Subject: Fw: Objection to proposed 40 houses – planning application Y/93/14/OUT - Addendum

Subject: Objection to proposed 40 houses – planning application Y/93/14/OUT

Reference: Y/93/14/OUT - Land North of Yapton C of E Primary School North End Road Yapton BN18 0DU

DRAWING NO YAP/DR/1

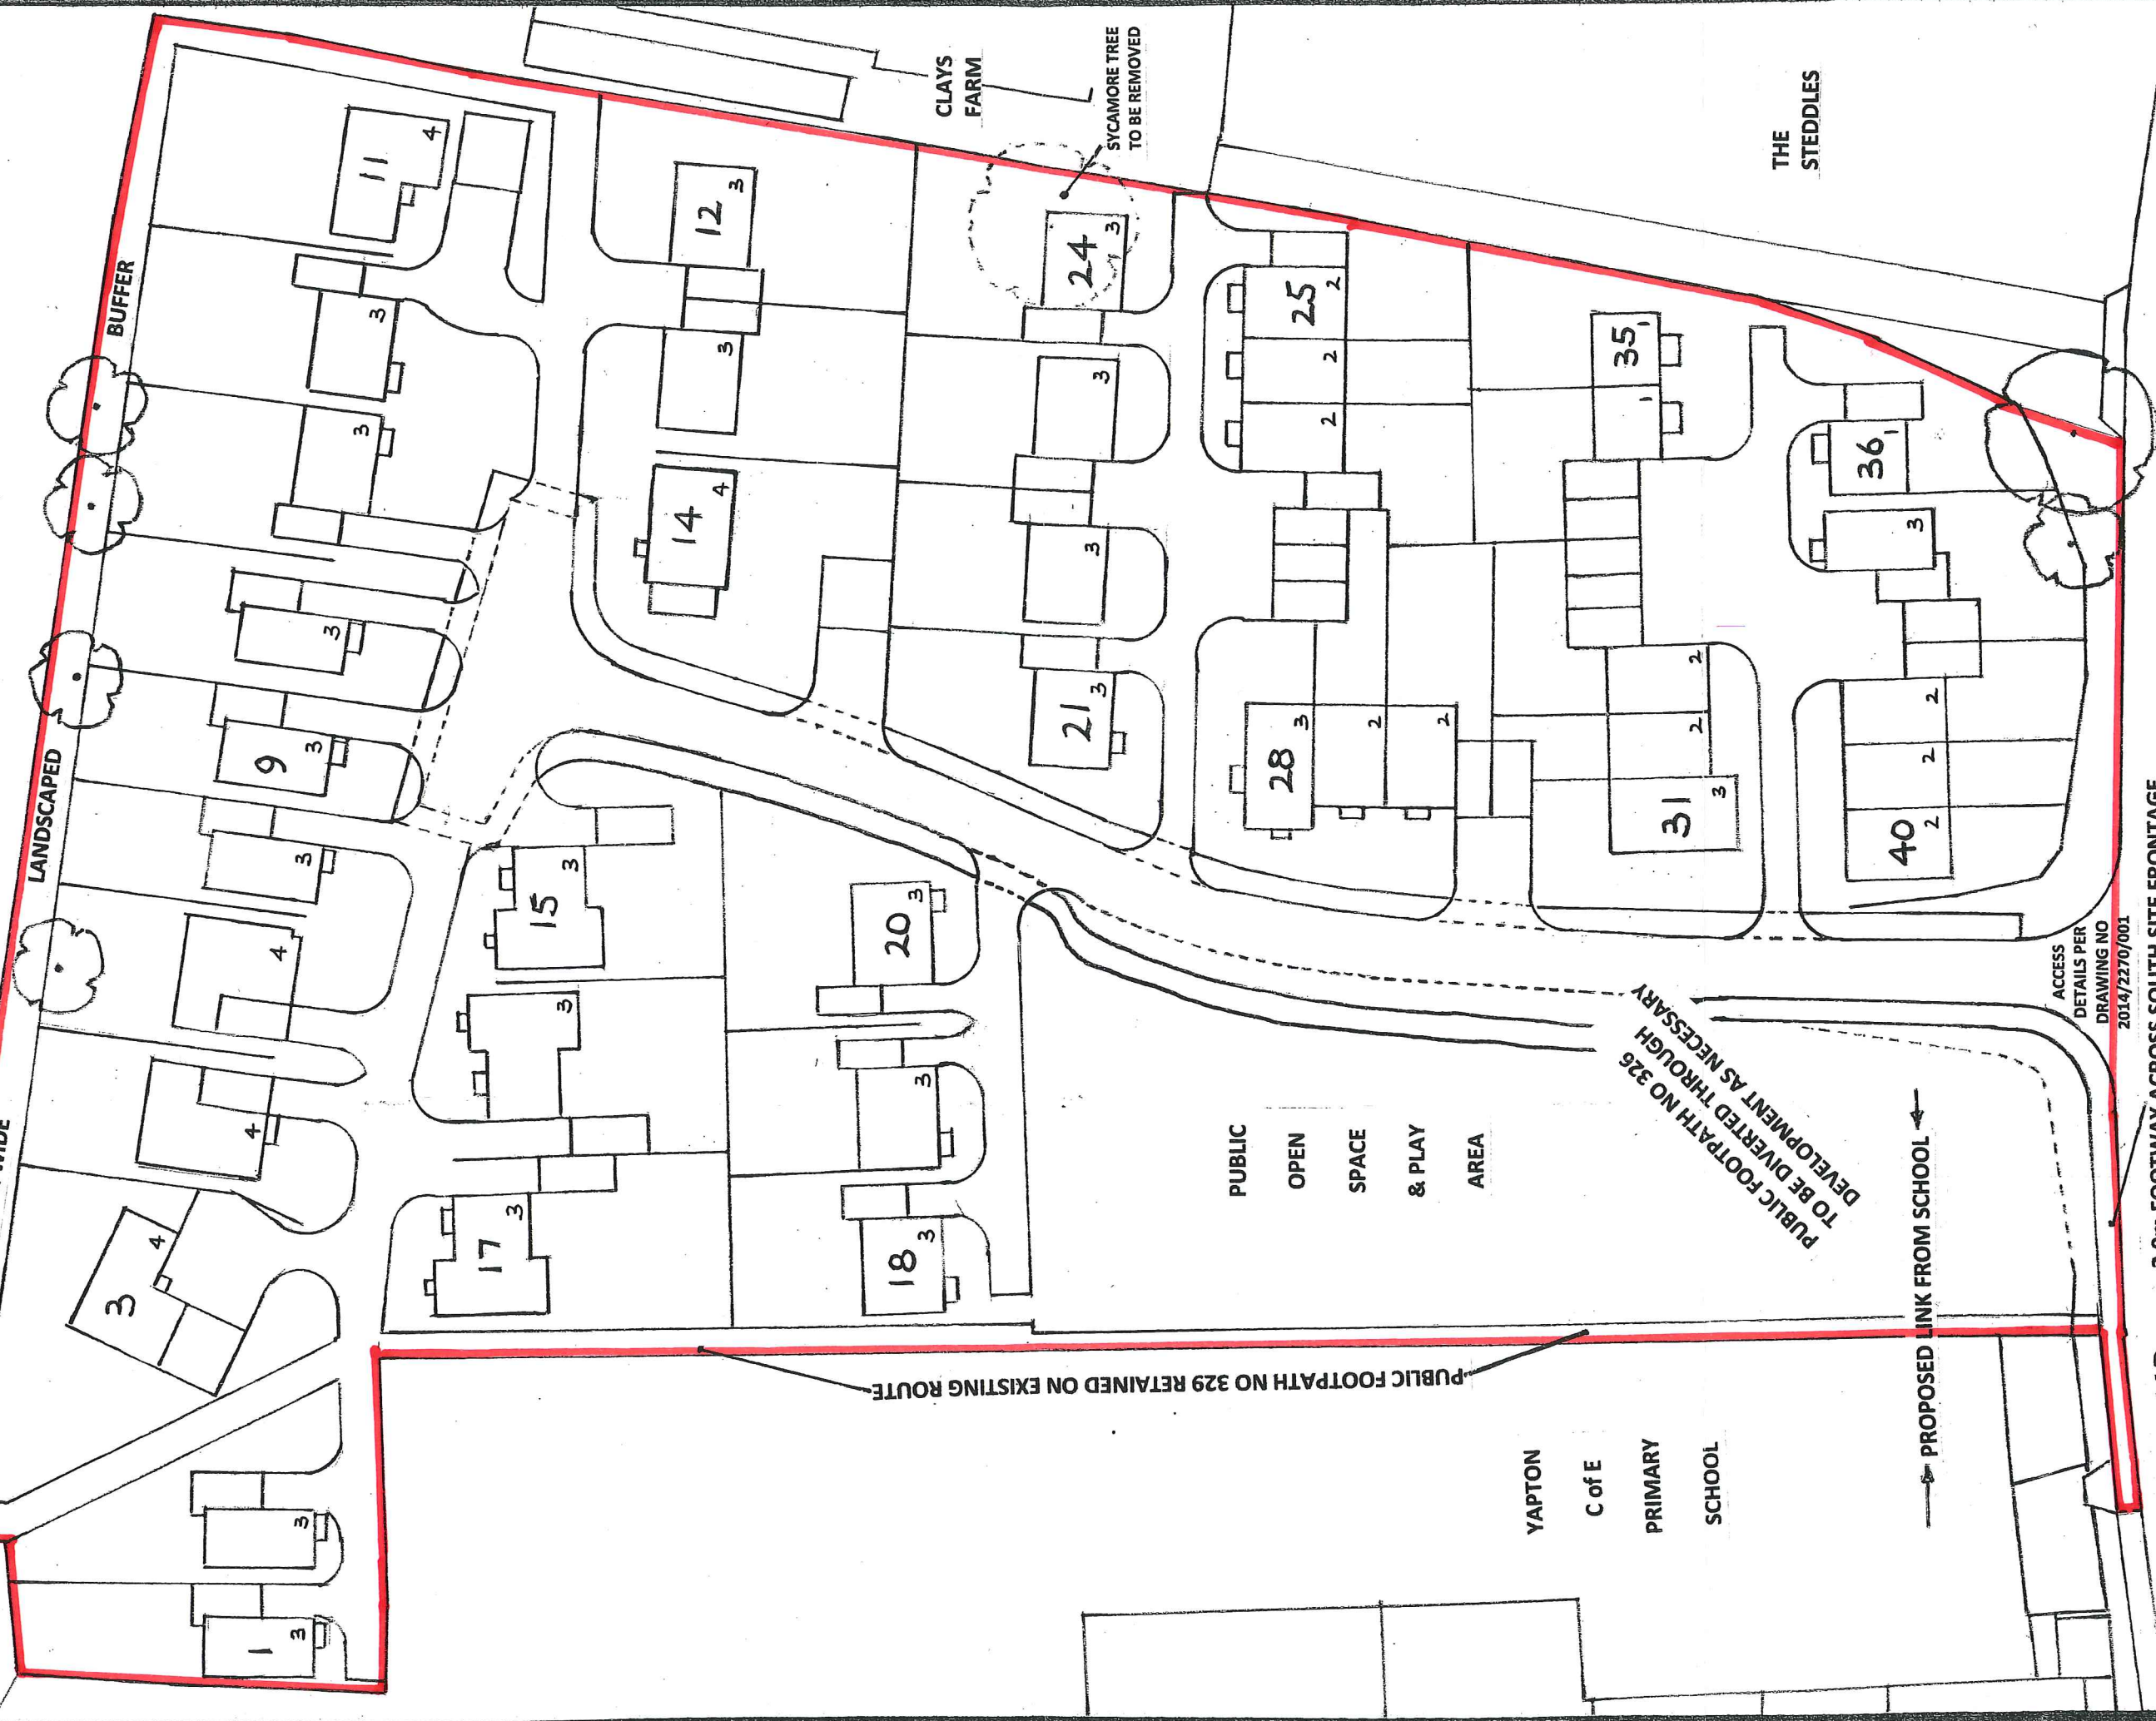
2) The proposal refers to 40 parking spaces based on 1 car per household although:

Both sets of information indicate that with a proposal of 40 houses we can expect in excess of this amount of additional cars on the proposed site and using the road (even taking into consideration for the limited number of 1 bedroom homes). In excess of 40 cars cannot be accommodated on the proposed site which will mean spill over on to North End Road which is already heavily congested during school pick up / drop off times.

3) The planning proposal suggests a "proposed link with school" may be considered - I note that this link is being proffered from the green space ie reduced green space and a "break" in the public footpath - is this correct? The green space is already limited in size for a development of this scale.
